From: [Haley Mercer](#)
To: [Zach Torrance-Smith](#)
Subject: RE: BL-25-00024 Haberman-Tirey - Notice of Application
Date: Monday, December 22, 2025 8:41:03 AM

Subject: BL-25-00024 Haberman-Tirey - Notice of Application

TO: All Staff
FROM: Public Works Plan Review Team
DATE: January 5, 2026
SUBJECT: BL-25-00024 Haberman-Tirey

## Critical Areas

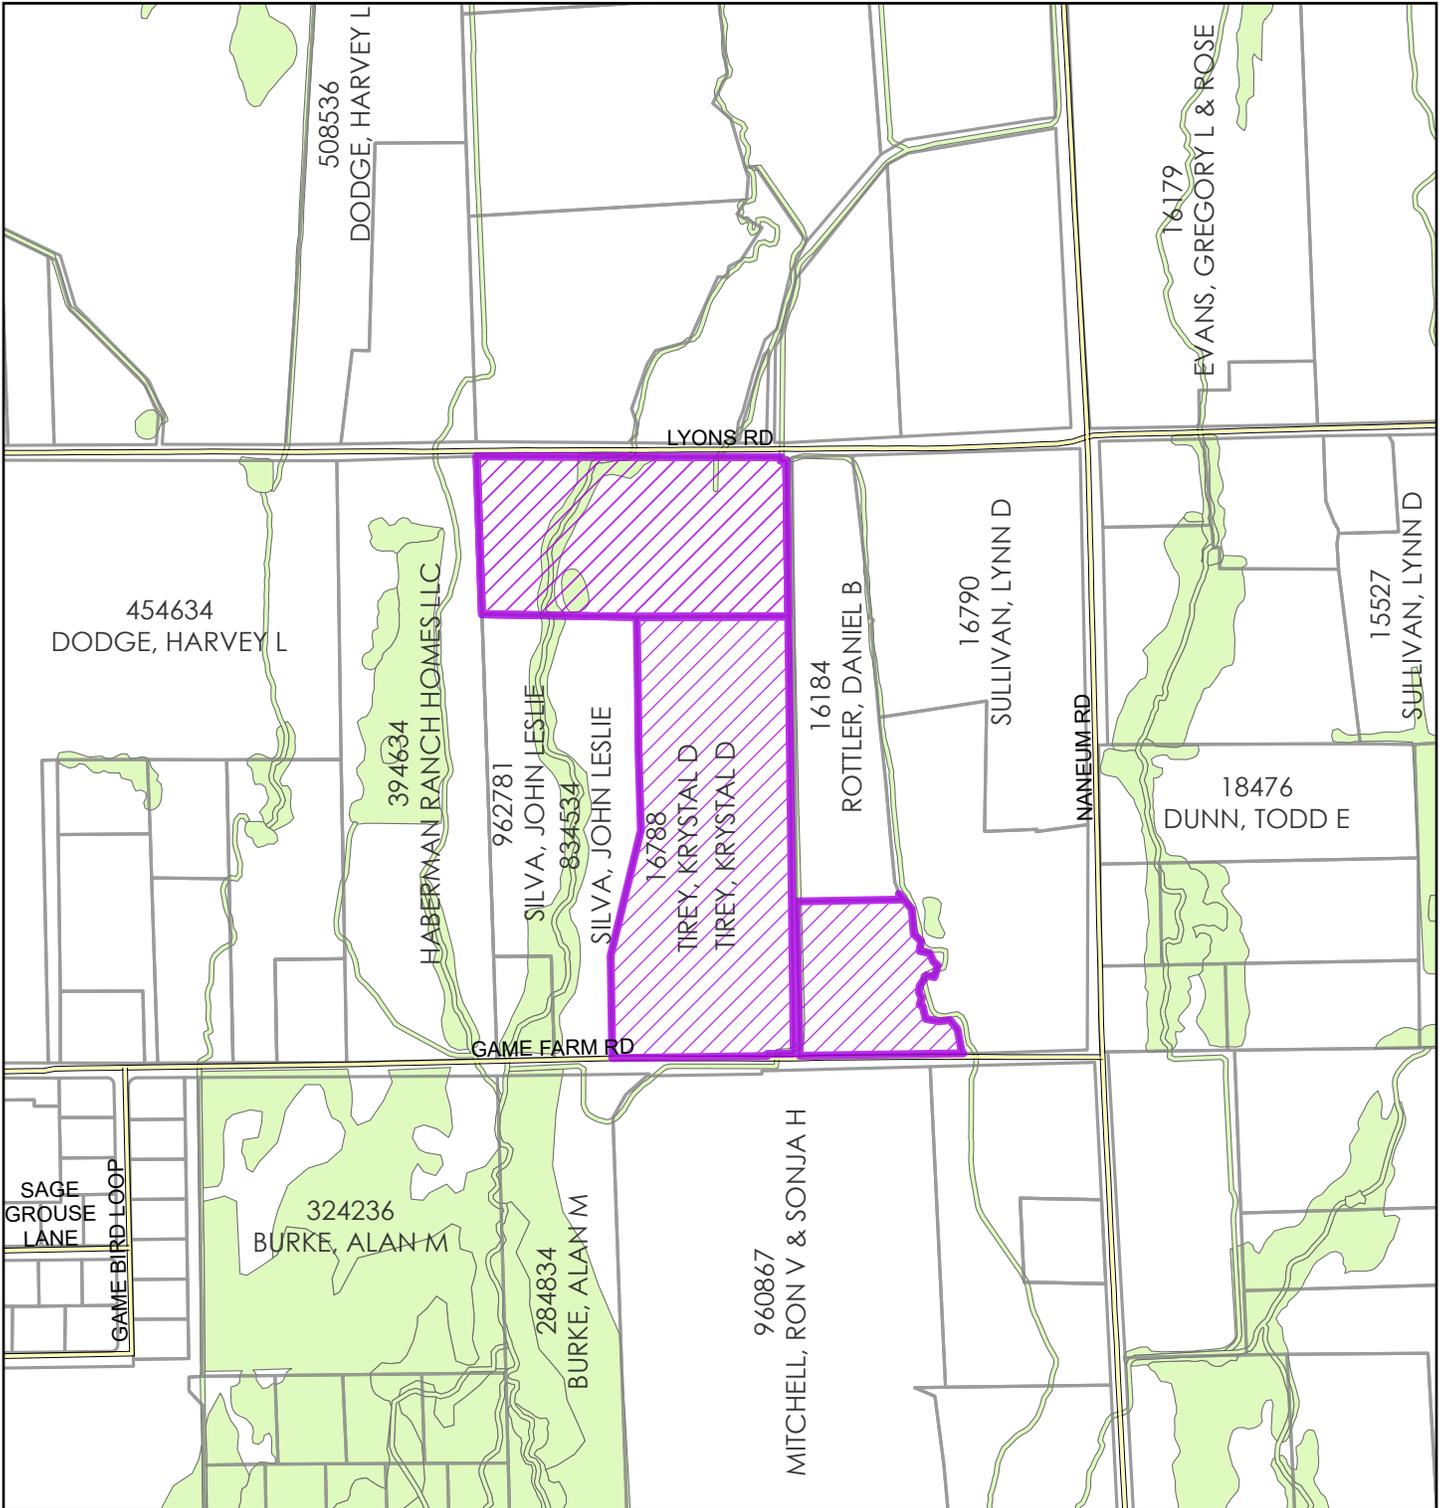
SURVEY	As the application does not contain a survey map, comments are herein reserved until final review. (JT)
TRANSPORTATION CONCURRENCY	No transportation concurrency requirement for this project. (RC)
FLOOD	A portion of parcel # 17648 is mapped within a FEMA identified special flood hazard area (1 percent annual chance flood zone). All development within the floodplain must be permitted through the floodplain development permit process and follow the regulations within KCC 14.08. While not required by KCC 14.08.220, it is highly encouraged that the floodplain boundaries are outlined on the face of the recorded survey. (SC)
WATER MITIGATION/ METERING	No comments. (SC)
AIRPORT	No Comment. (RC)
